Major Projects Assessment

SUBMISSION EIS NO.2
NWRL
APPLICATION NO. SSI-5414

FROM: TED & MARGARET SIMPSON
7 OLIVER WAY,
CHERRYBROOK. 2126

Figure 6.12 Cherrybrook Station - Indicative vehicle and pedestrian movements

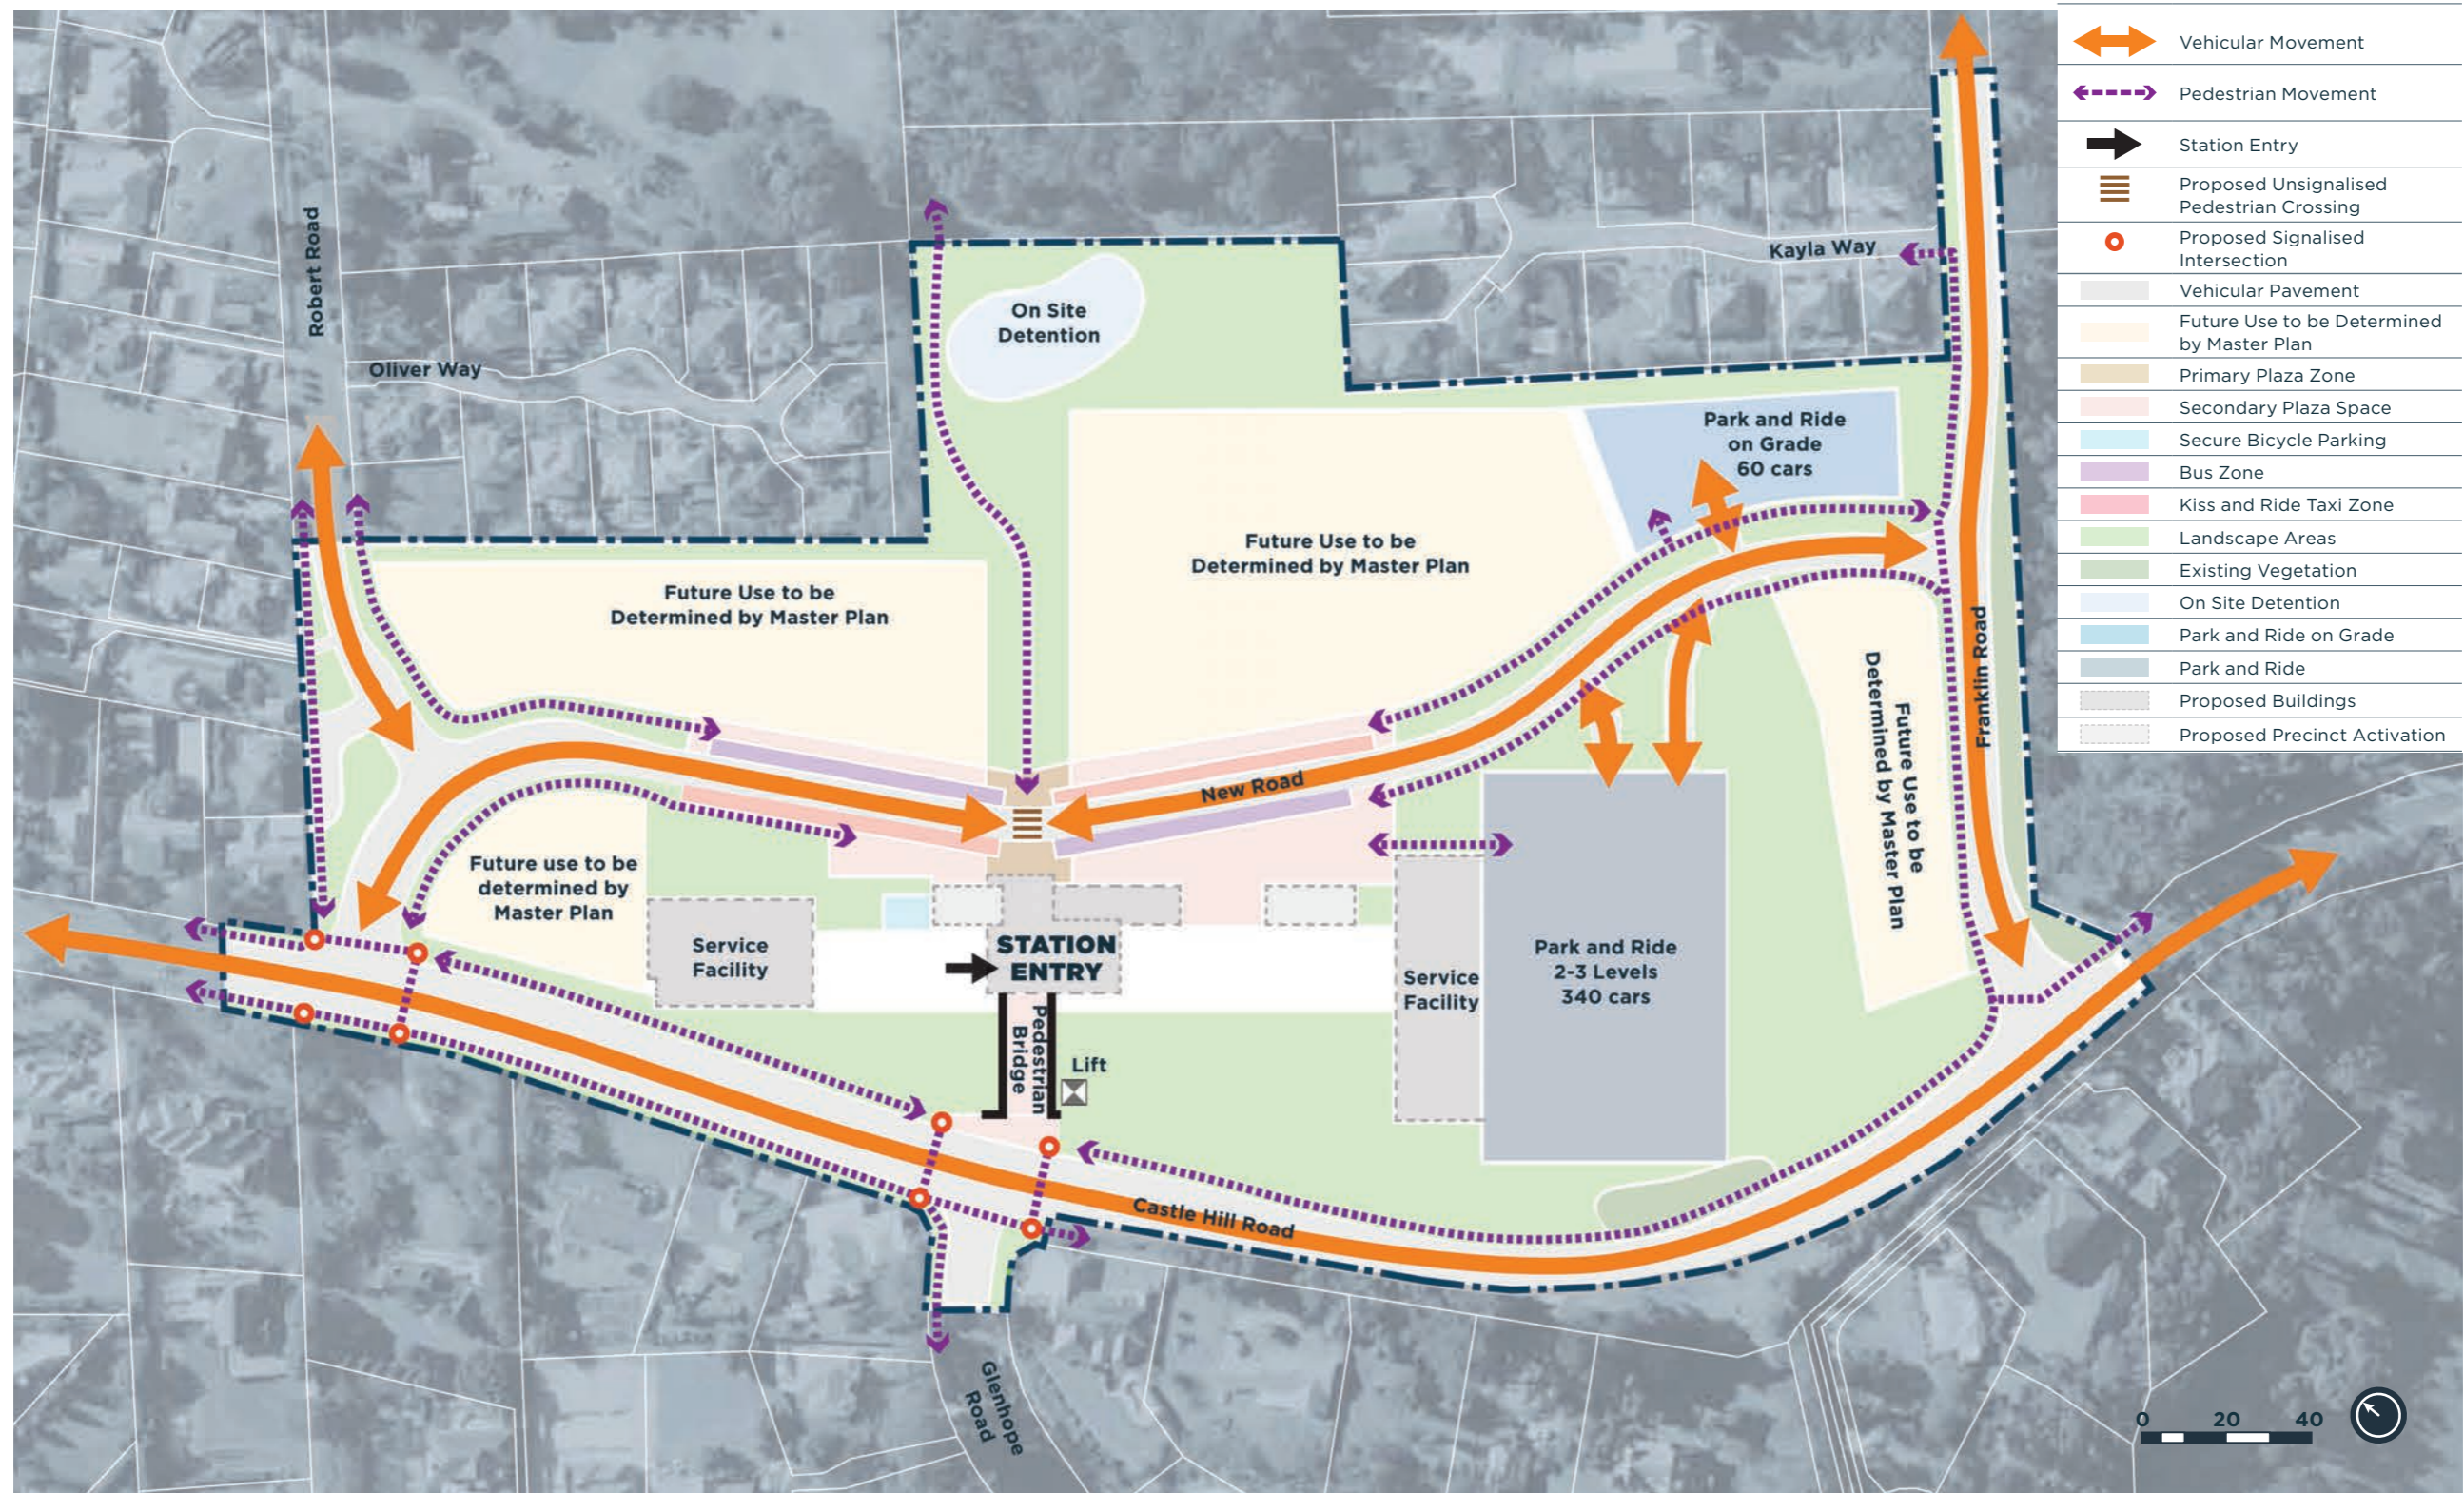
1. USE OF ROBERT ROAD FOR BUS TRAFFIC AND THE PROVISION OF
'NO PARKING' SIGNS ON BOTH SIDES OF ROBERT ROAD

Robert Road is a residential street which is totally unsuitable for the provision of bus traffic to and from the proposed Cherrybrook Station.

The proposal to reroute buses currently turning left from County Drive into John Road then Robert Road is totally without foundation as the only buses using John Road are buses to the City, Pennant Hills and Hornsby stations.

County Drive has sufficient width to provide a 'bus only' left turn lane at the intersection of Castle Hill Road and should it be necessary there is sufficient width of reservation on Castle Hill Road from the intersection of County Drive to provide a 'bus only' lane for more than two thirds of the way towards Robert Road.

Robert Road is already being used as a 'rat run' during morning peak periods and the most desirable outcome consistent with buses via County Drive and Castle Hill Road would be to cul de sac Robert Road at Castle Hill Road with enhanced pedestrian access into the Station precinct.
